RE: SSD-87245208 at 13-17 Oxford Street and 2 Verona Street, Paddington

Thank you for notifying Sydney Water of SSD-87245208 at 13-17 Oxford Street and 2 Verona Street, Paddington, which proposes the demolition of some existing structures, construction of a seven storey mixed-use building over three basement levels comprising 44 apartments, cultural and creative uses (including a cinema/bar) and retail uses, basement parking and rooftop and ground level communal open space, alongside the construction of a three-storey residential terrace building with four apartments and rooftop private open spaces. Sydney Water has reviewed the application based on the information supplied and provides the following Sydney Water requirements to assist in understanding the servicing needs of the proposed development.

Heritage – Busby’s Bore

Drawing Title
SECTION - CULTURAL CREATIVE & COURTYARD

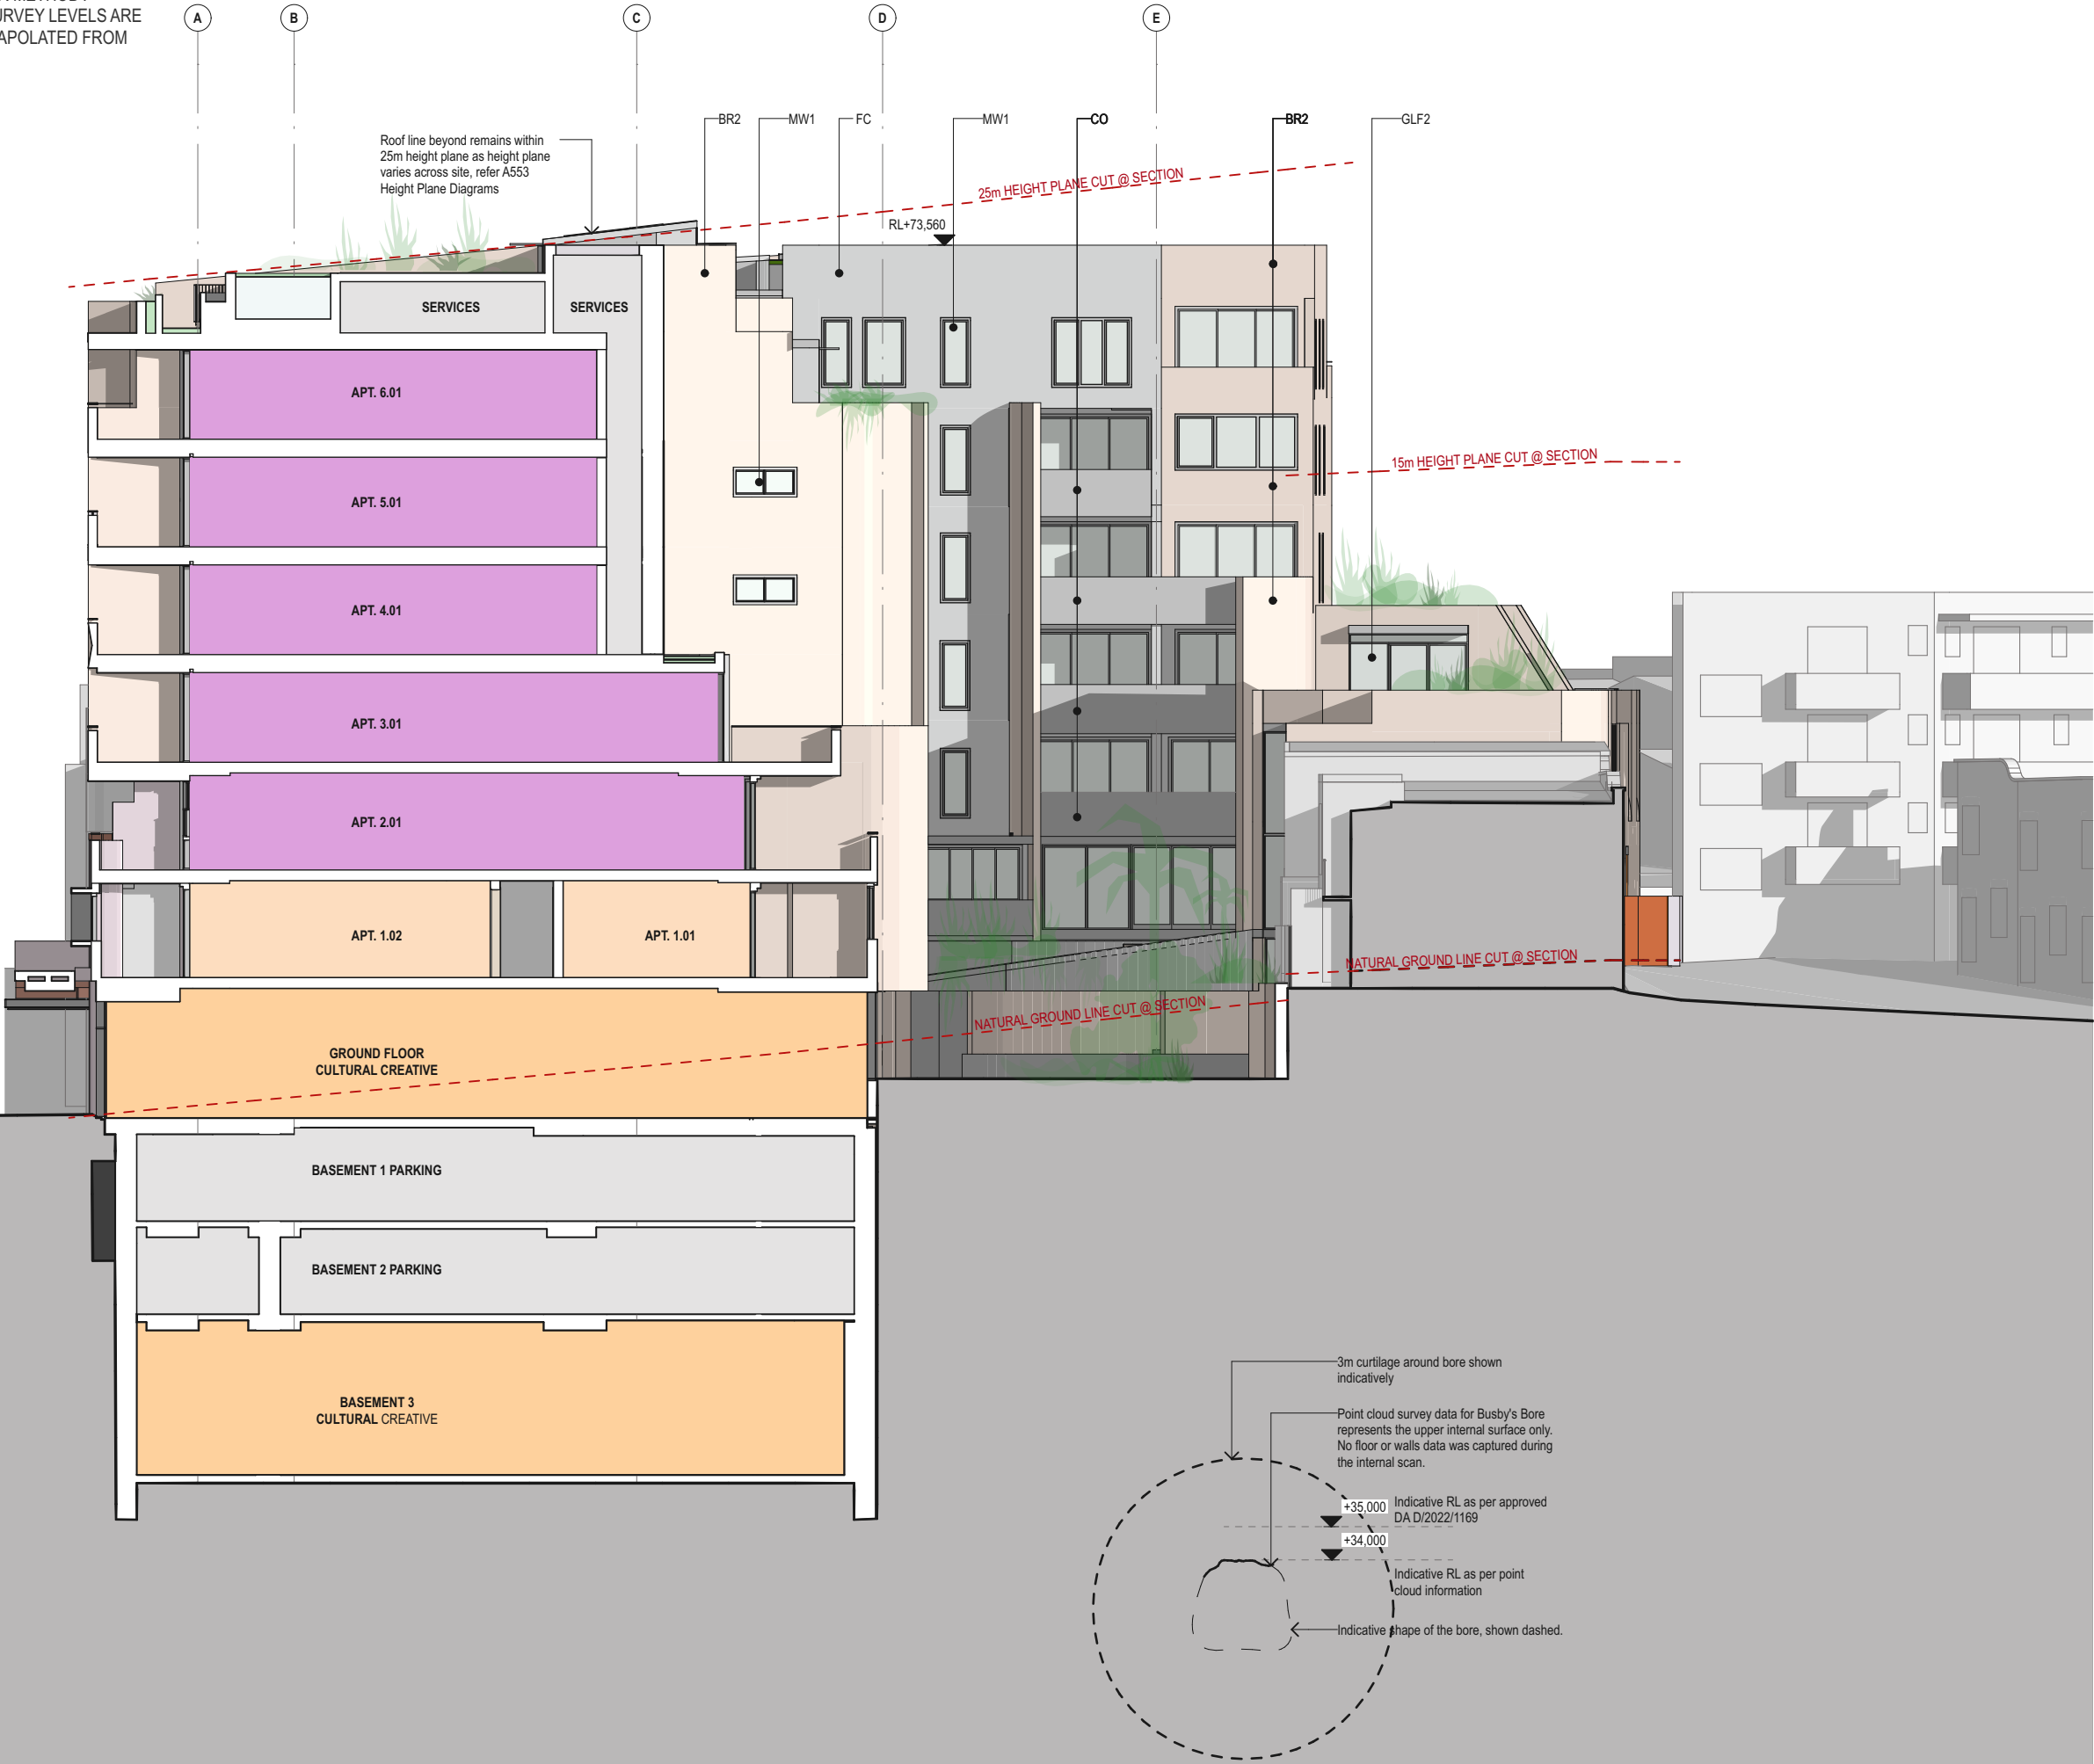
- The proponent should show the location of Busby’s Bore in the Section plans, demonstrating the proposed separation from basement excavation and construction and relative depth compared with the proposed new building basement levels.

- The proponent is required to address the above heritage comments and provide Section plans showing the location of Busby's Bore, demonstrating the proposed separation from basement excavation and construction and relative depth compared with the proposed new building basement levels.
- **The Department is advised to re-refer this SSDA to Sydney Water for review once heritage comments have been addressed.**
- The Department is advised to forward the enclosed Sydney Water Development Application Information Sheet (for proponent) to assist the proponent in progressing their development. This Info Sheet contains details on how to make further applications to Sydney Water and provides more information on Infrastructure Contributions.
